Application: 3/2020/0205

Application Site: Spencers Farm, Past Lane Bolton by Bowland

Proposal: Conversion of agricultural building to holiday let

The Granary
Proposed Elevations and Plans
Scale 1:50 @ A1

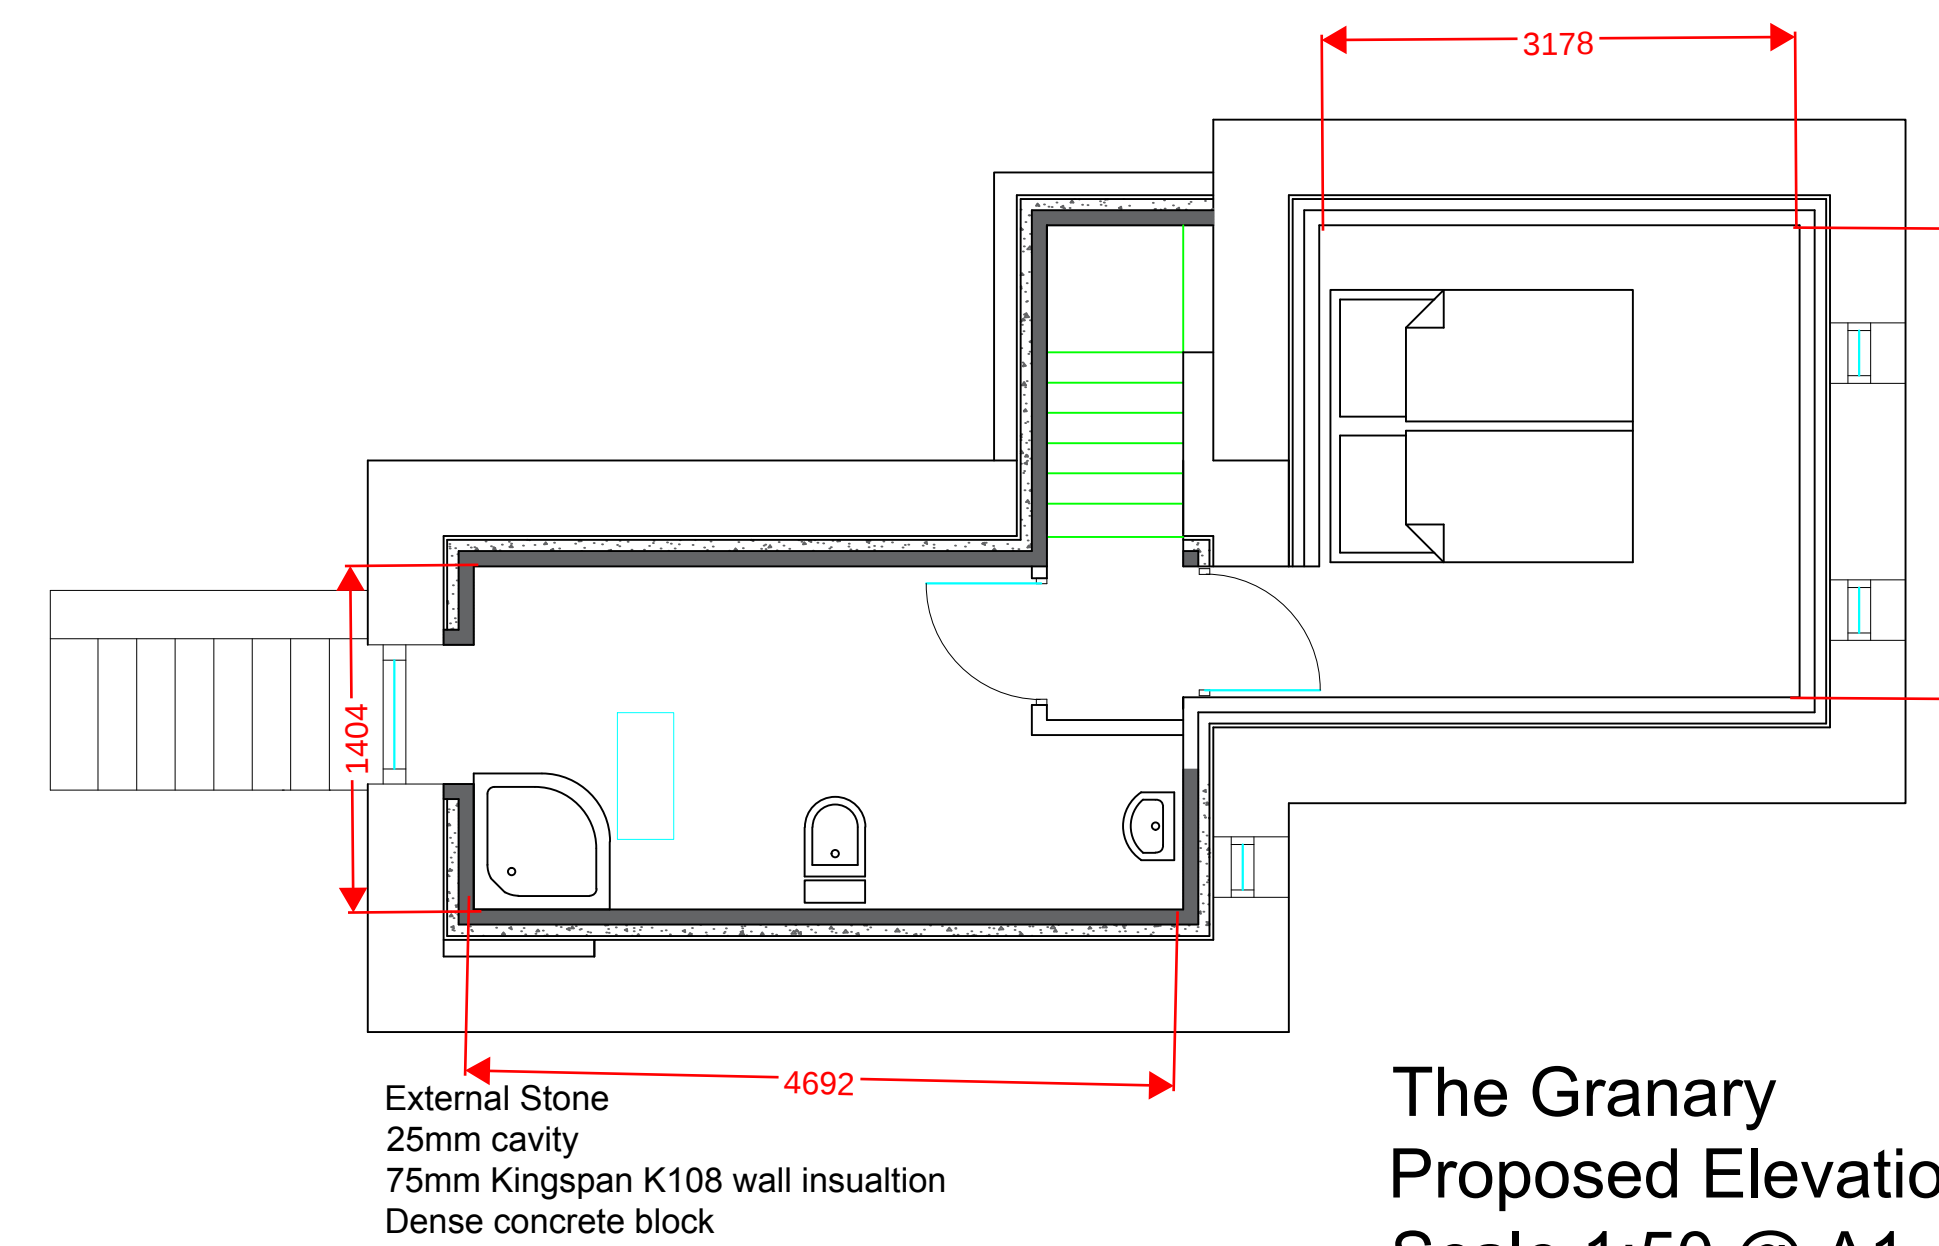
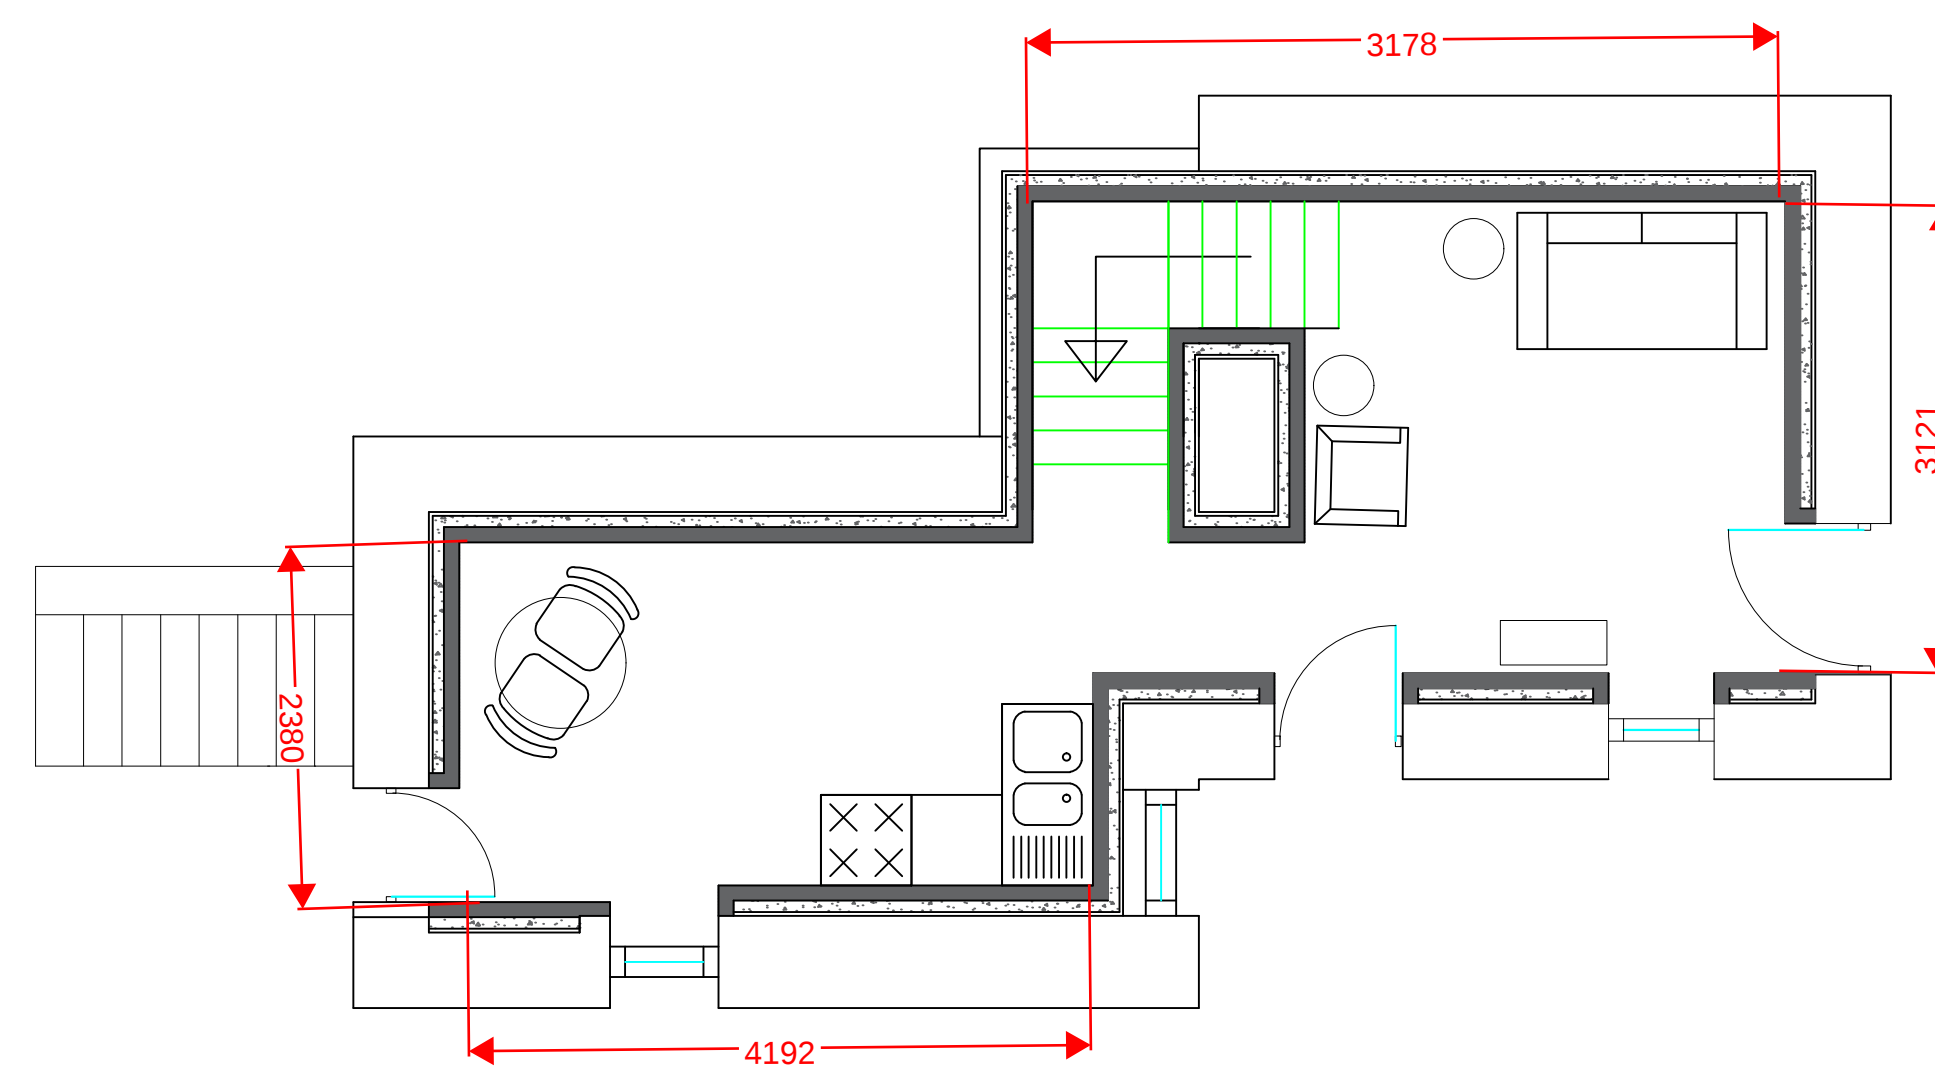
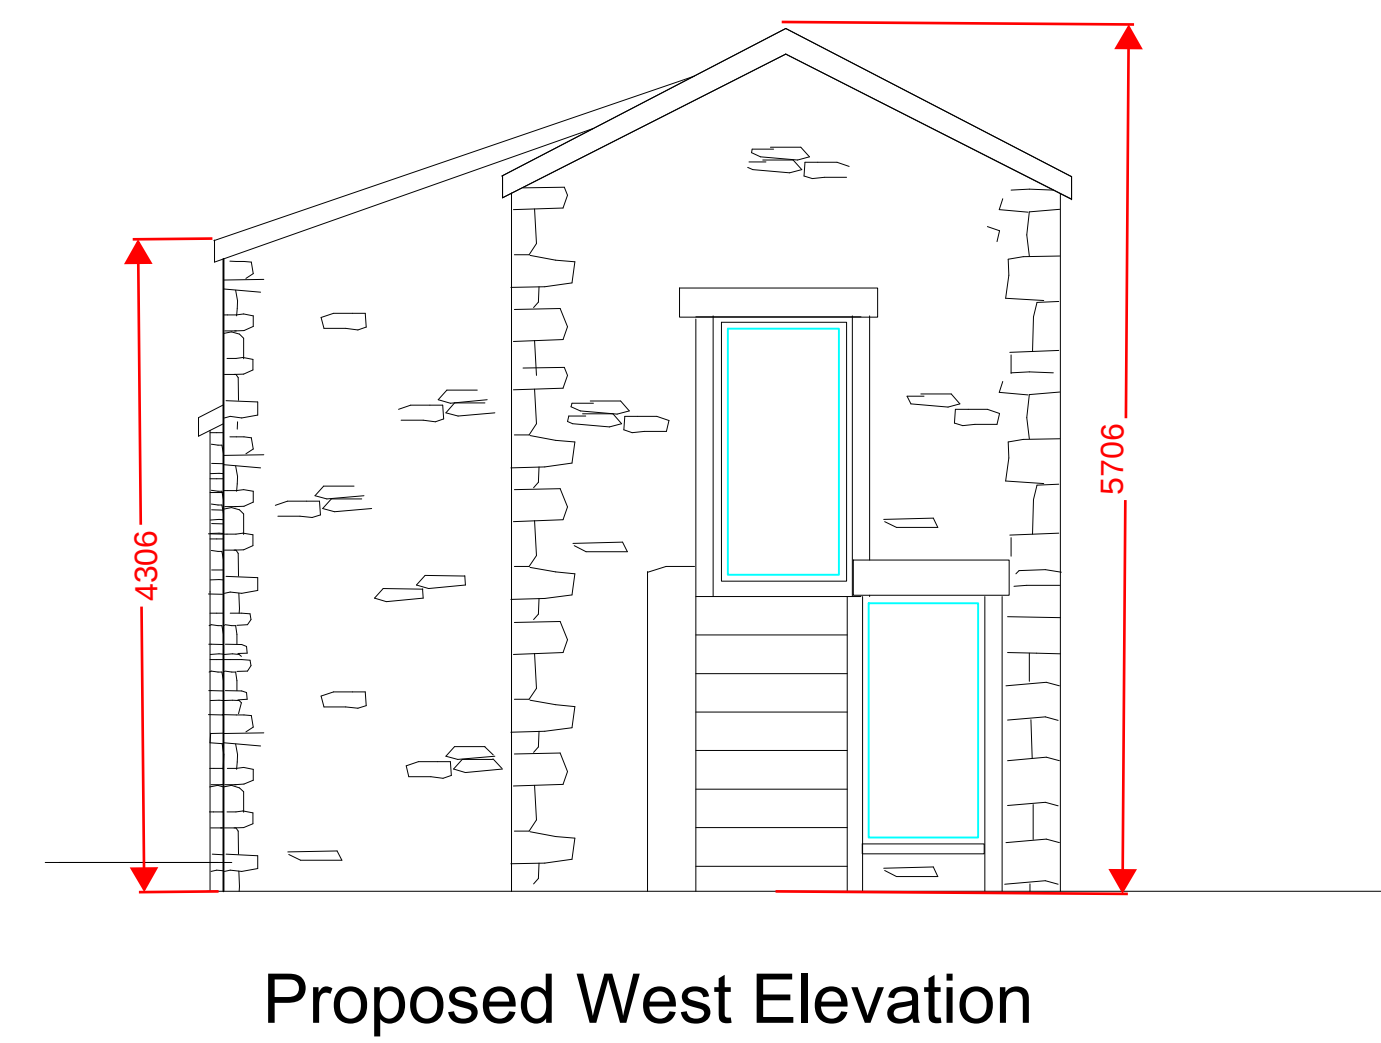
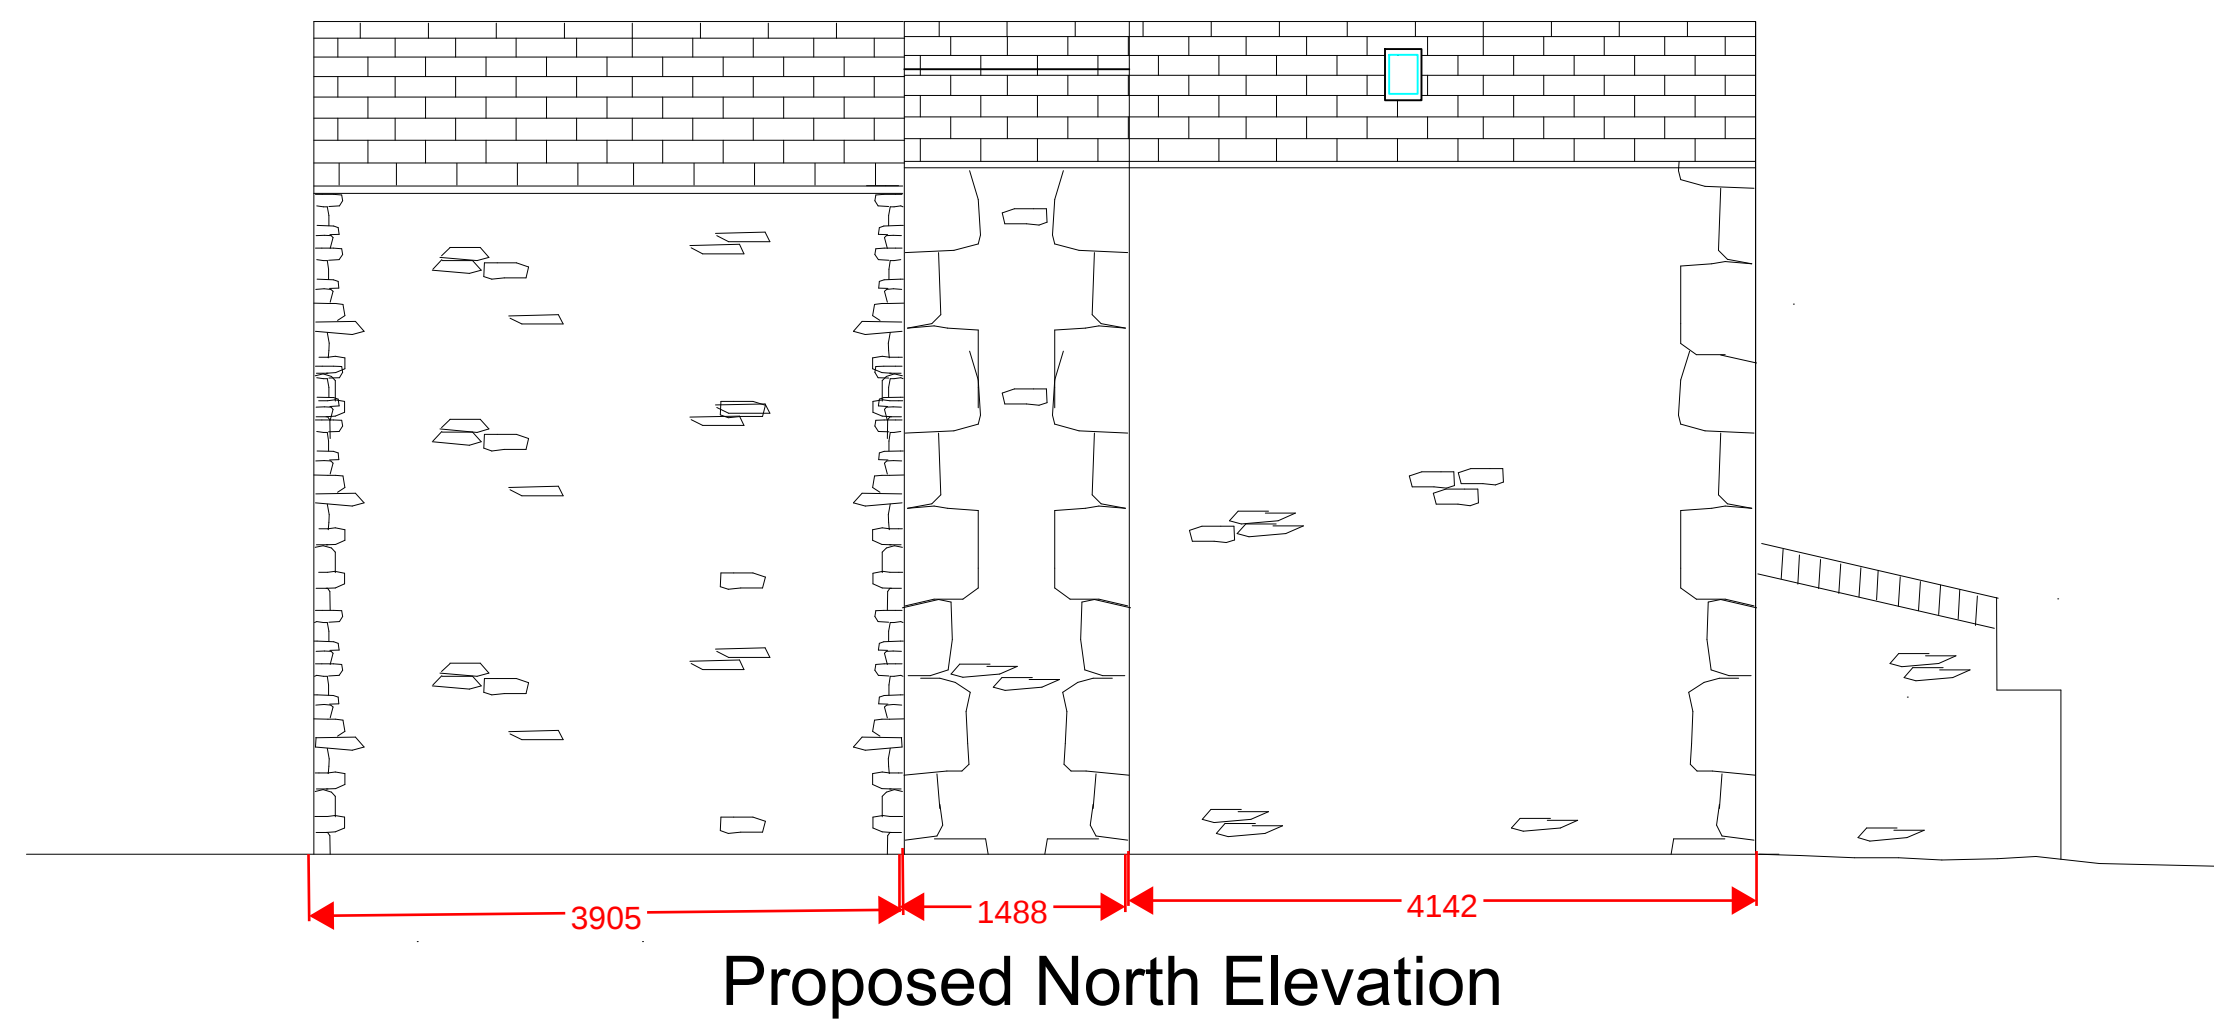
2 the parking of the vehicle shown in the sit layout would appear to be obstructing the vehicular access to the farmhouse. Would it be possible to amend the plan showing the parking facilities for both the farmhouse and the proposed development?
